Ref 2022/0687 – Advertisement Consent Application

Proposal: Internally illuminated hanging and projecting signs set within unit frontage and privacy vinyl's applied to first floor windows

Address: Community Diagnostic Centre, The Glass Works, Barnsley, S70 1GW

Ground Floor Proposed Plan

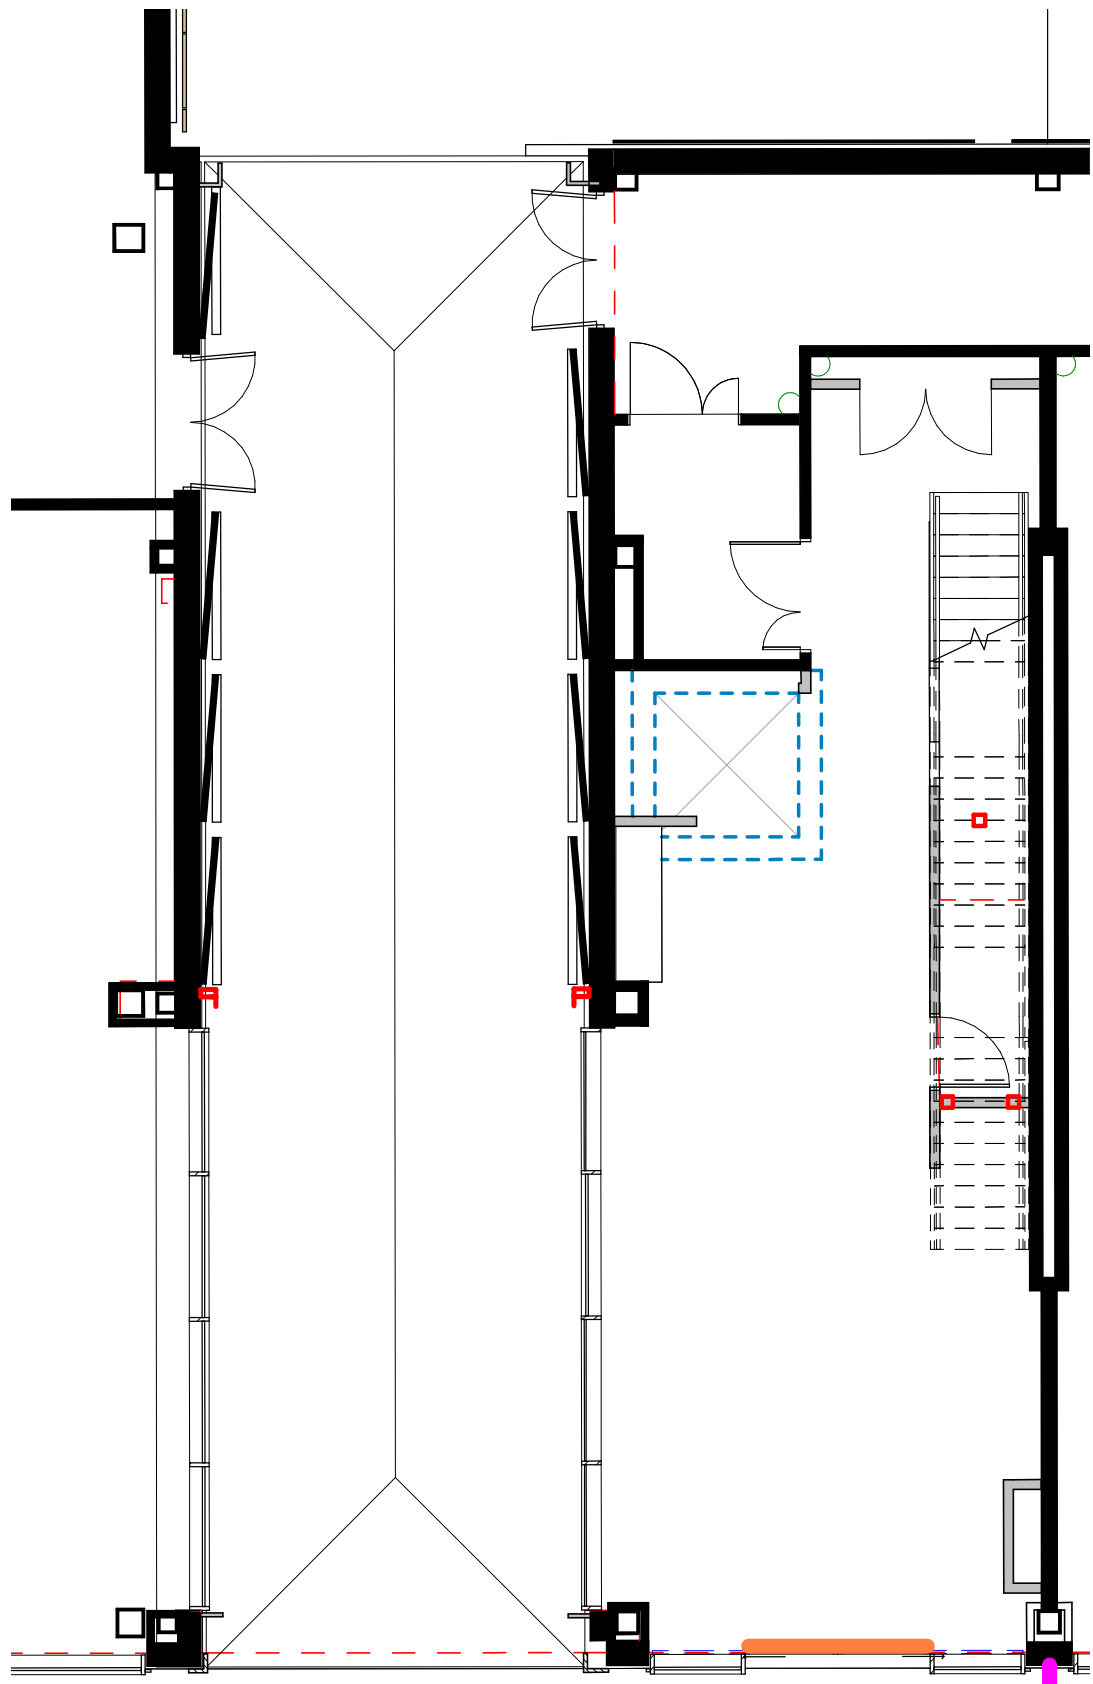
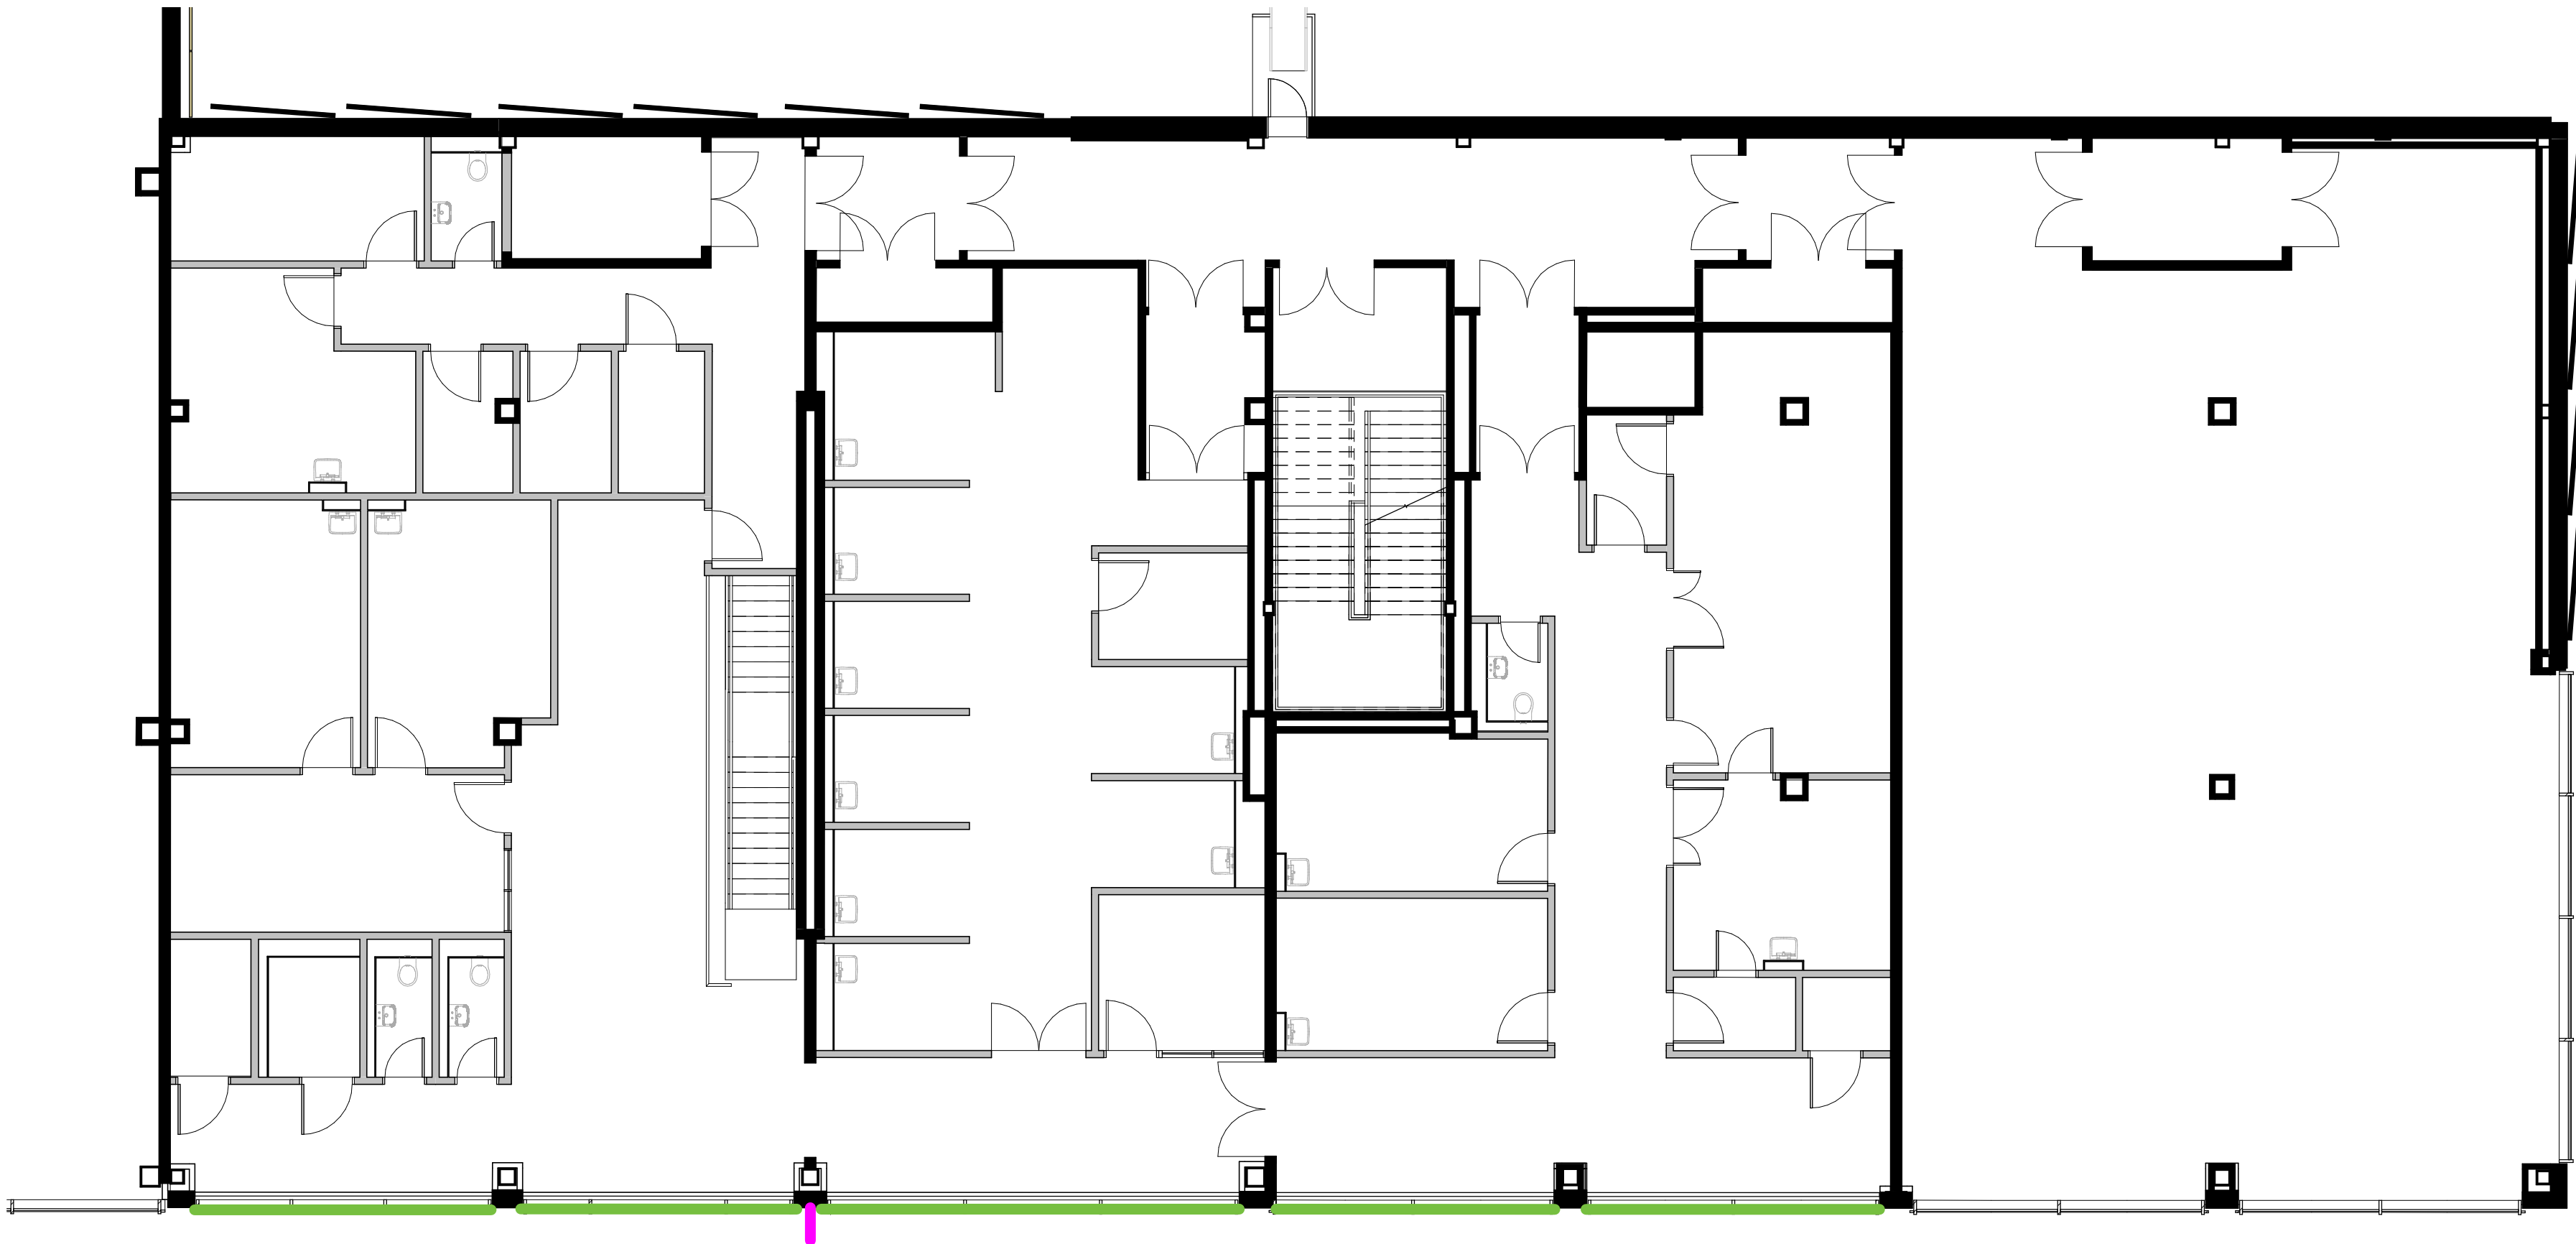
Design – Initial comments – I am fine with the hanging and projecting signs provided the projecting sign is fitted flush to the pillar and not with a connecting 'arm'. I note that the latter may have to be moved as it appears to conflict with an existing CCTV camera. Seeks clarification and amendments to the vinyl to secure transparency, an overriding theme of the Glass works shopfronts design guide

The internally hung and internally illuminated hanging sign is acceptable. Following adverse comments from the Design Officer, the application has been amended to move the location of the internally illuminated projecting sign which would otherwise have conflicted with an existing CCTV camera and to redesign the method of fixing such that it is fitted flush to the pillar. Both signs are proposed to have illumination of 600cd/m²

- The vinyl has been amended to maximise the amount of clear glass (and therefore transparency)
- The privacy vinyl has been removed from the ground floor unit
- The projecting sign now sits flush with the wall per other projecting signs around the development and has been moved to avoid a clash with an existing CCTV camera.

Proposed Privacy Vinyl Pattern

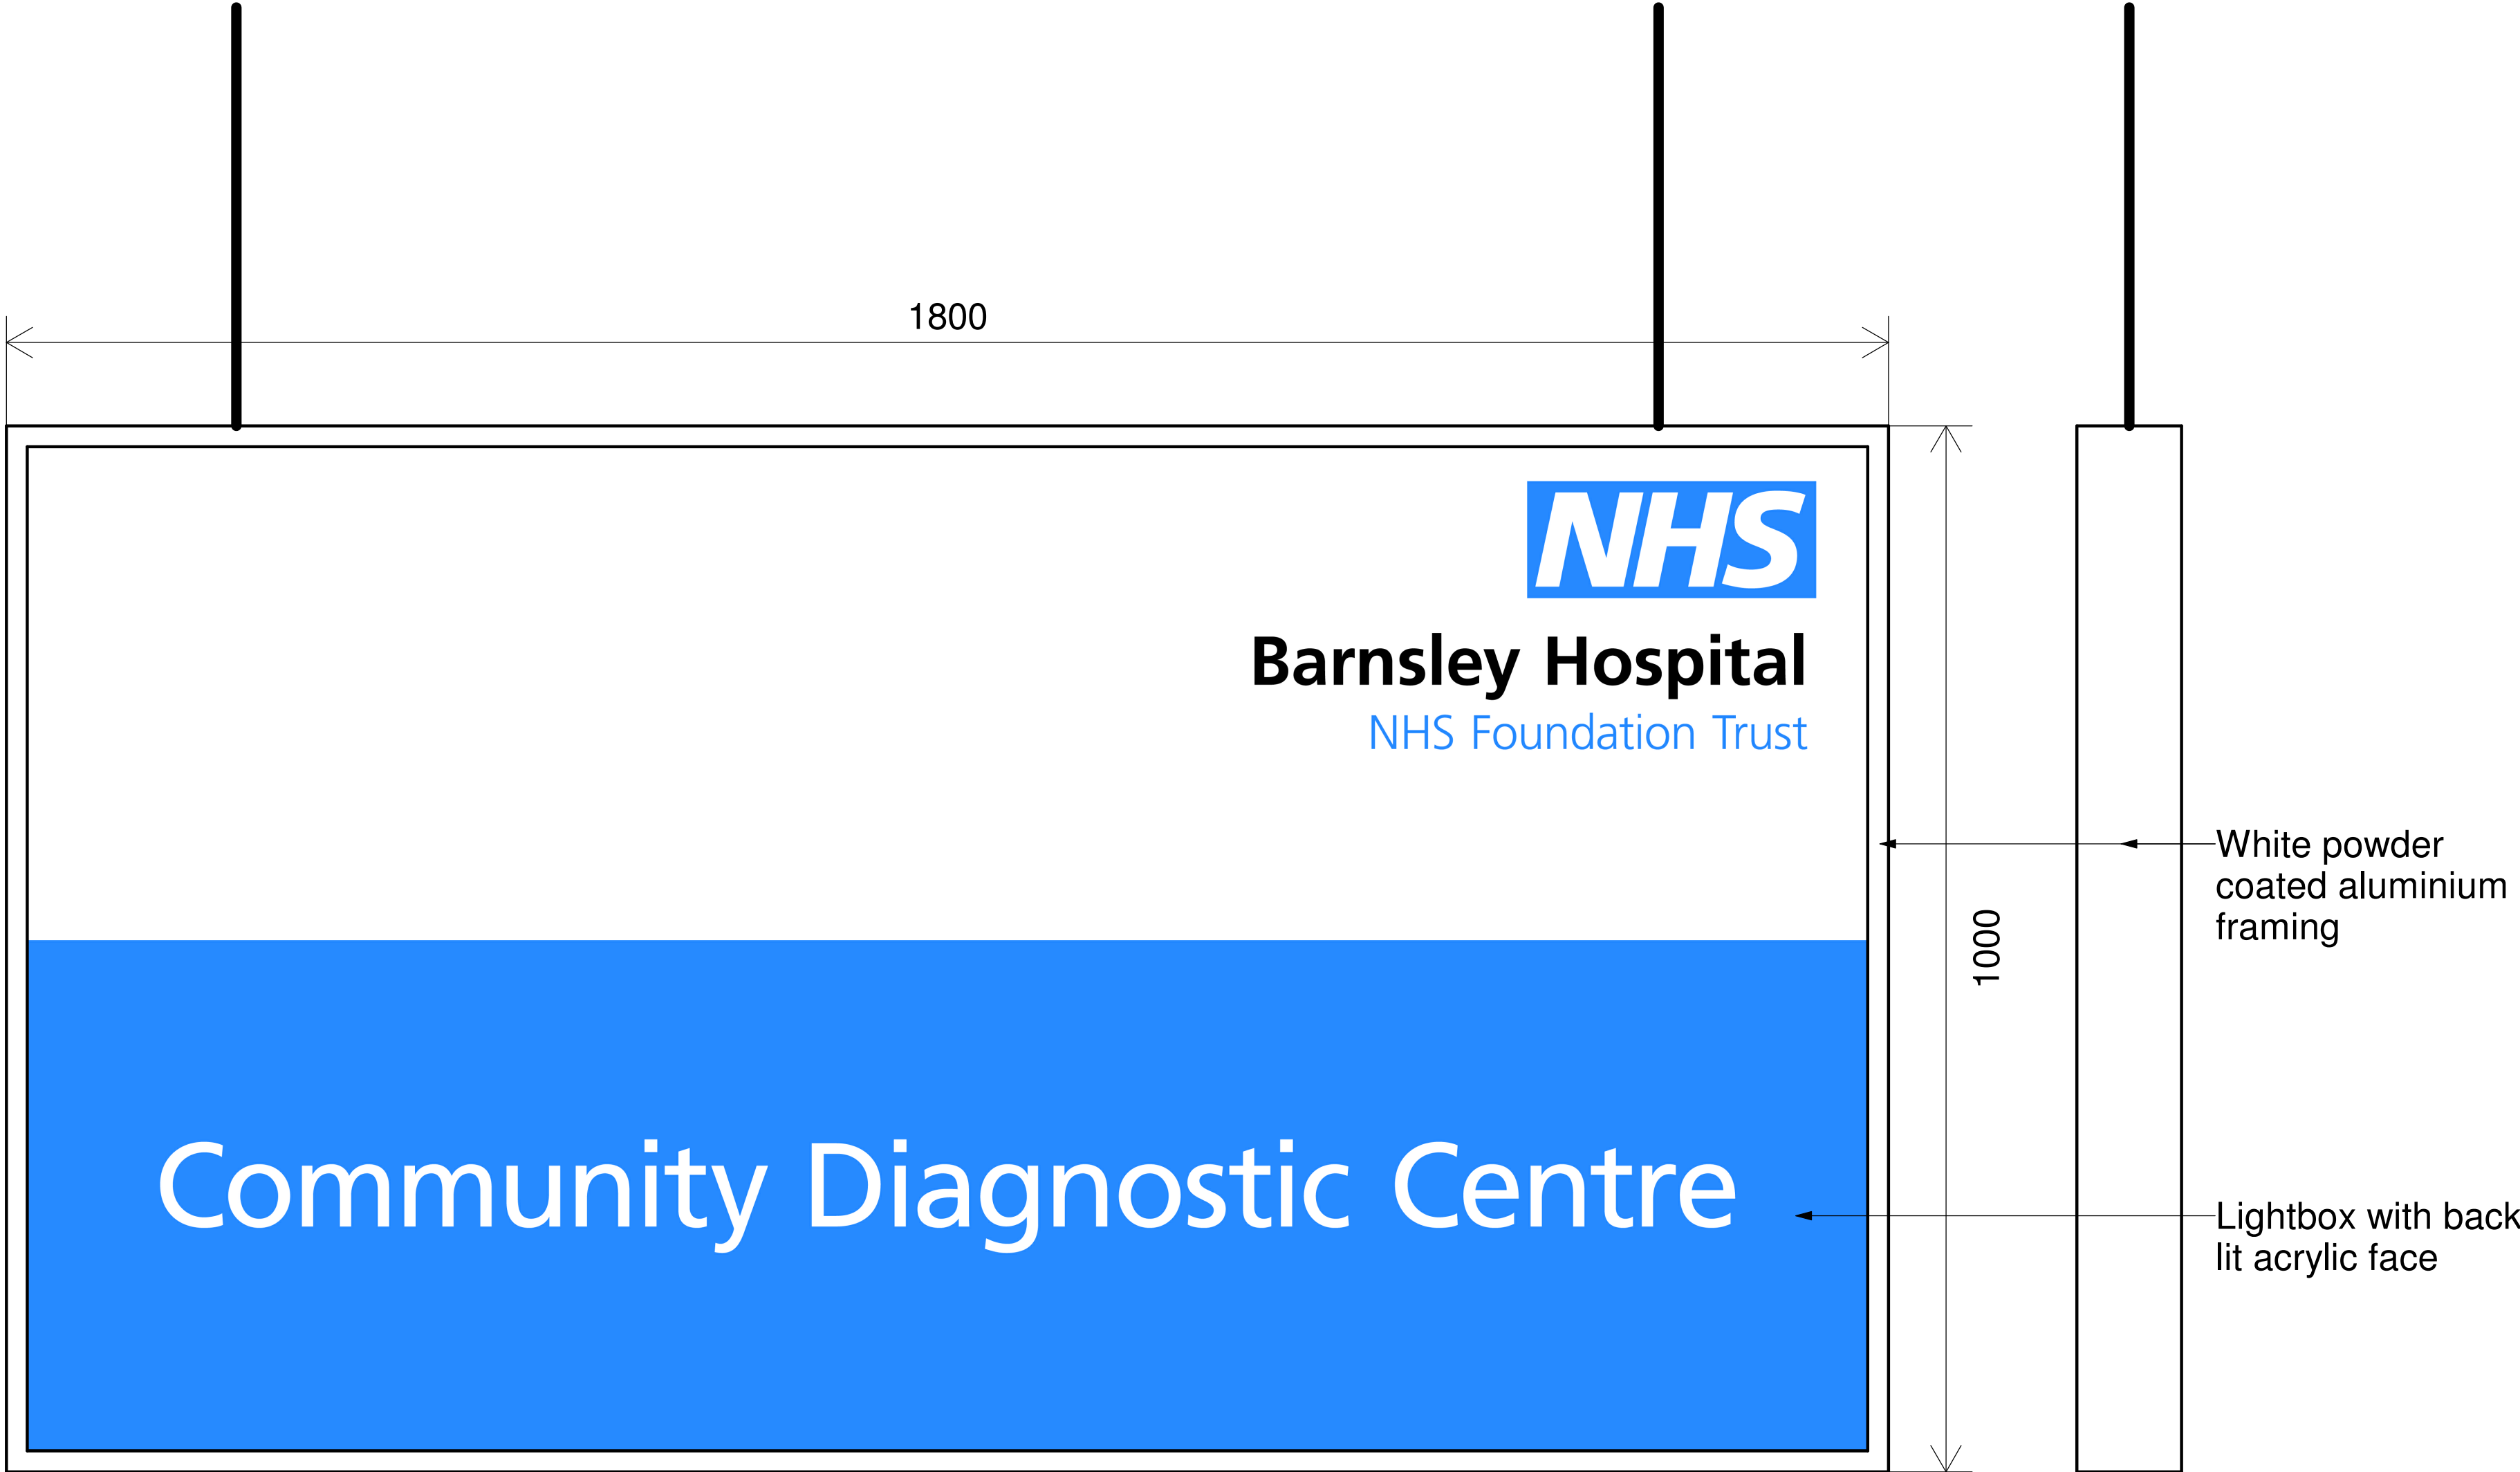
Amendments have also been secured to the proposed privacy vinyl, including changes to the size and method of application and to the location of the vinyl, reflecting the Design Officers comments seeking to agree a compromise whereby some degree of privacy is provided given the sensitive nature of the use. It has been concluded that as amended, this is an acceptable compromise between the transparency requirements of the shop front design guide and the specialist use of this unit.
